TII26-136785

Re: Strategic Infrastructure Development Application for the Littleton Wind Farm comprising of 11 no. turbines and all associated works, Co. Tipperary

ACP case ref. PAX92.324370

**Legend**

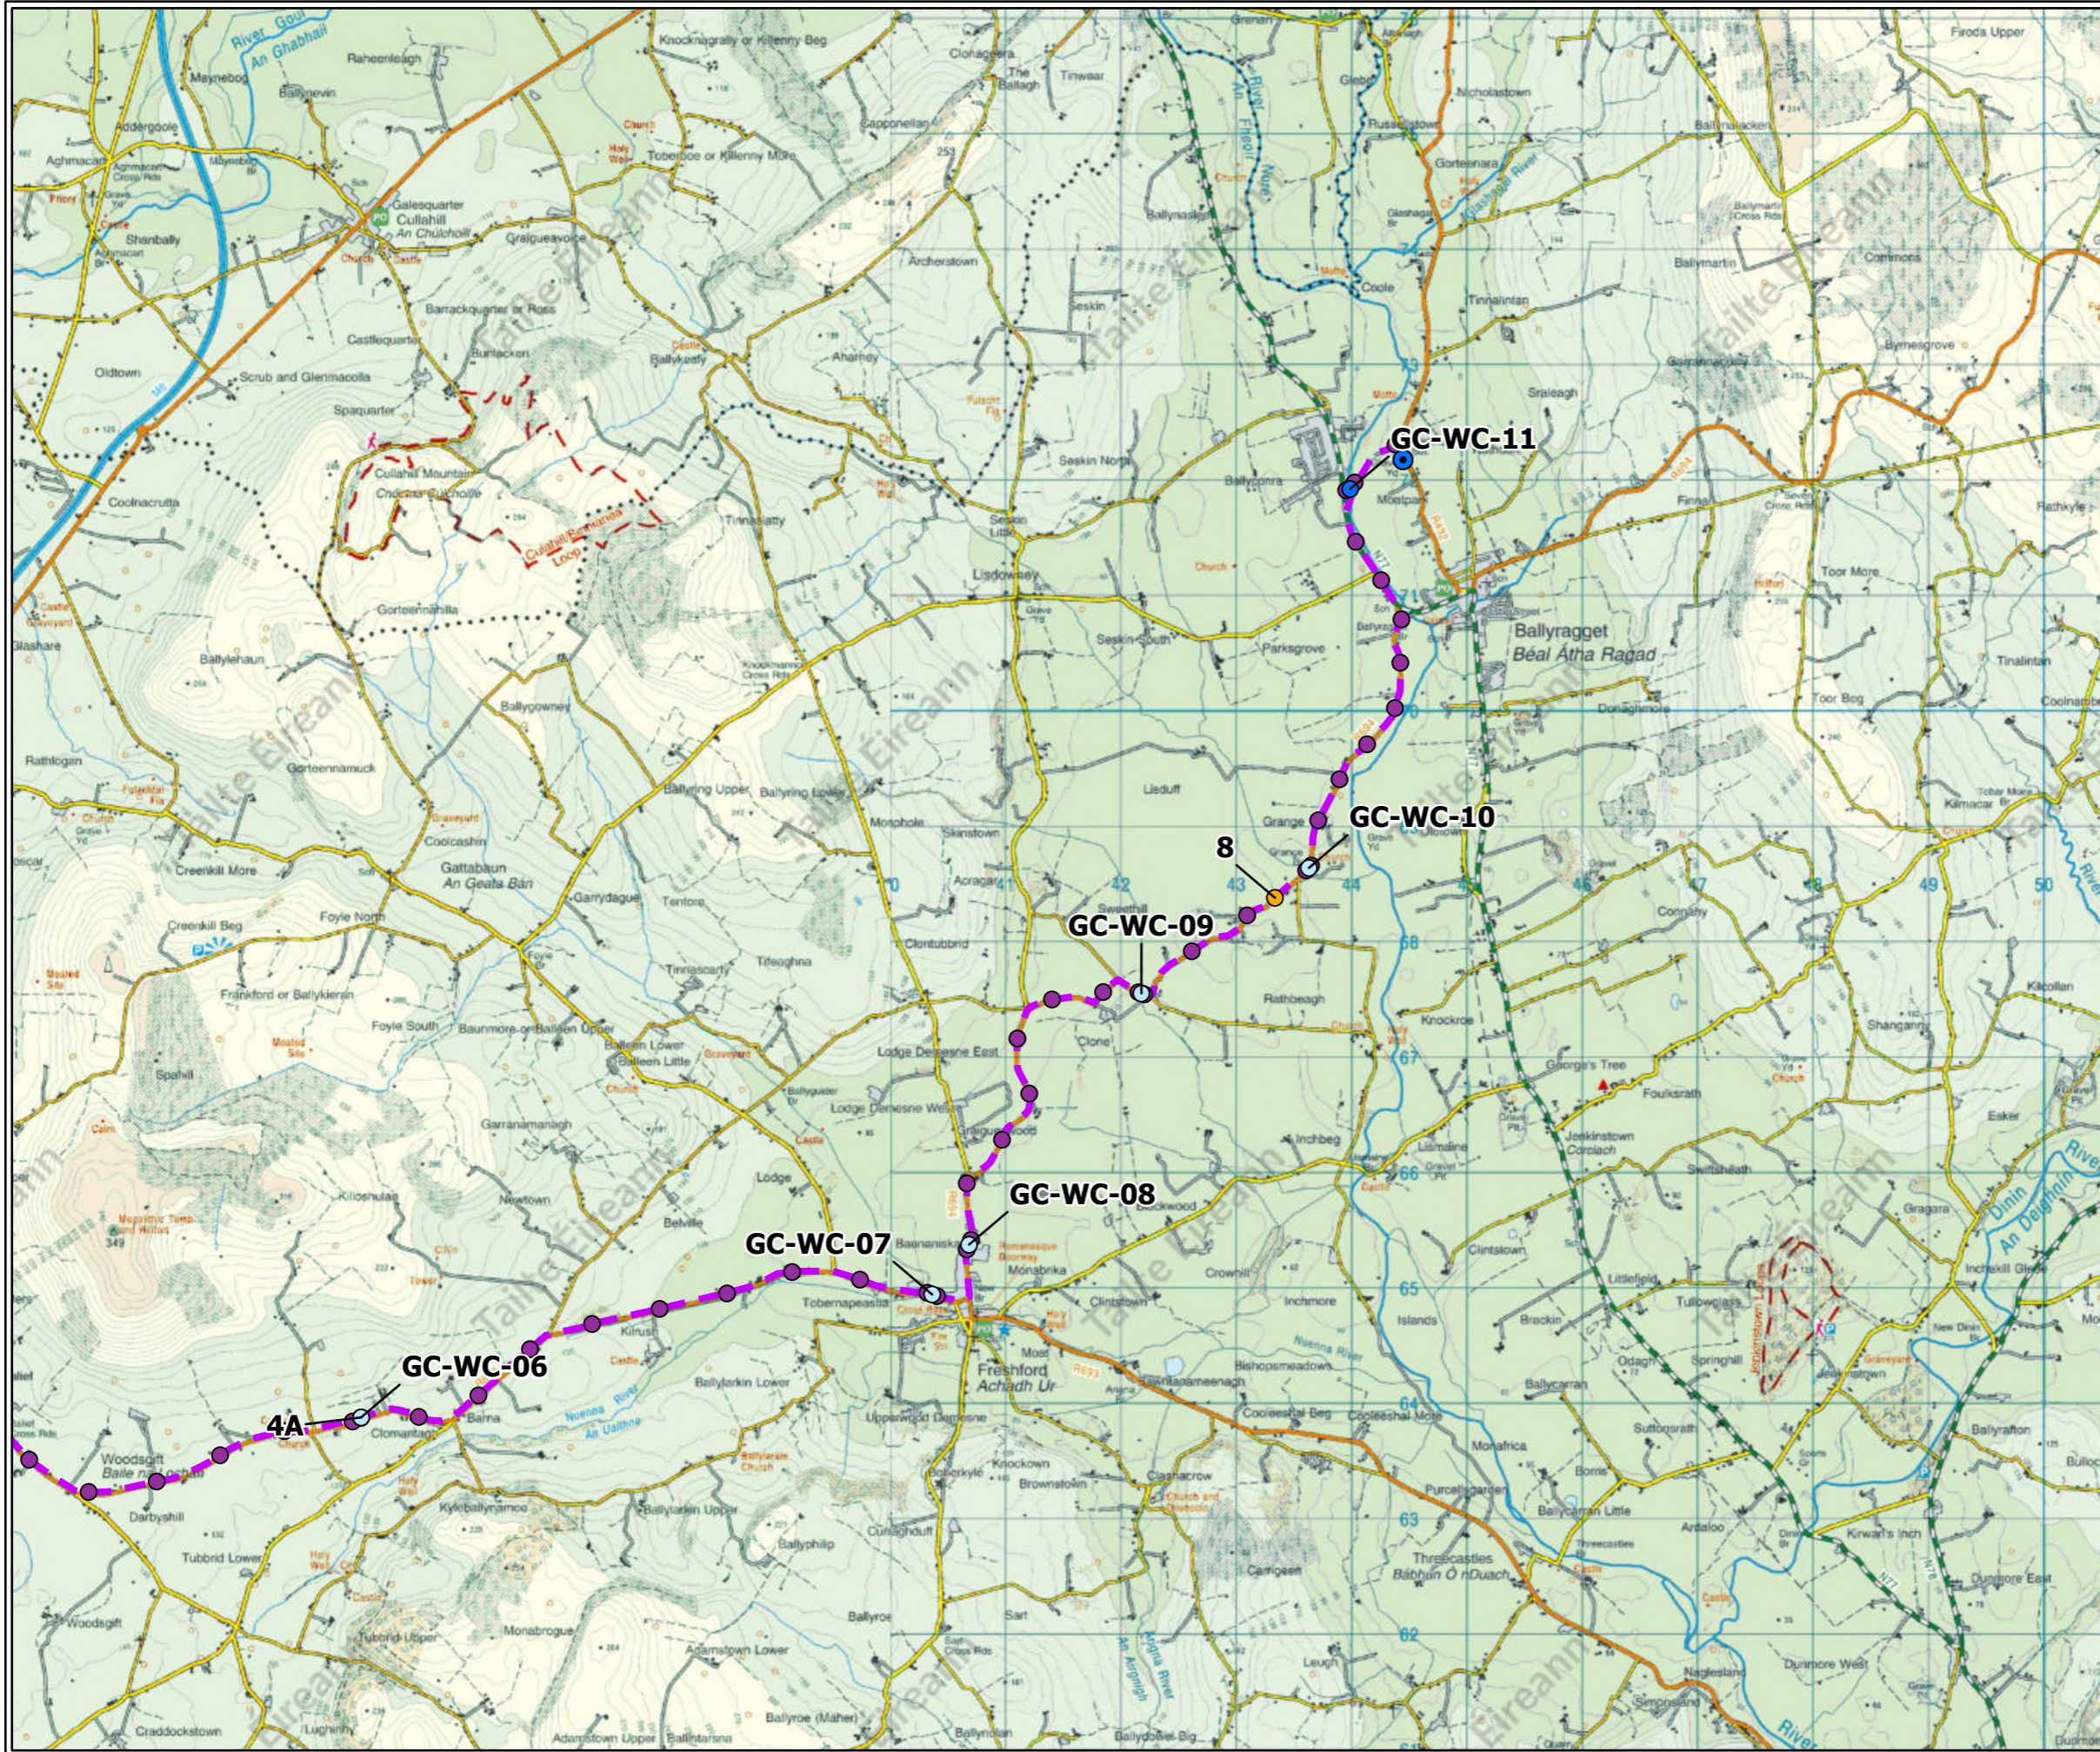
The grid connection routing to the Ballyragget 110kV substation details approx. 1km of grid connection routing along the N77 and possibly 3 no. joint bays in the N77 road reservation. The Commission will be aware of a number of renewable energy development proposals grid connections to the Ballyragget 110kV substation with routing identified along the same sections of the N77, national road. For example, Kilkenny County Council planning application references 23/60248 and 25/60003 refer.

Clarification may be necessary to demonstrate that proposals can all be accommodated in the finite road space, where proposed grid connection routes interact. Opportunities to co-ordinate proposals in that regard, to ensure deliverability and to mitigate impact to the road network, may be available.

Having regard to the measures identified in CAP24 and the information in relation to grid routing included in the subject application, TII recommends that the applicant demonstrate and the Commission be satisfied that the proposed grid routing in any subsequent application represents the optimal routing solution.
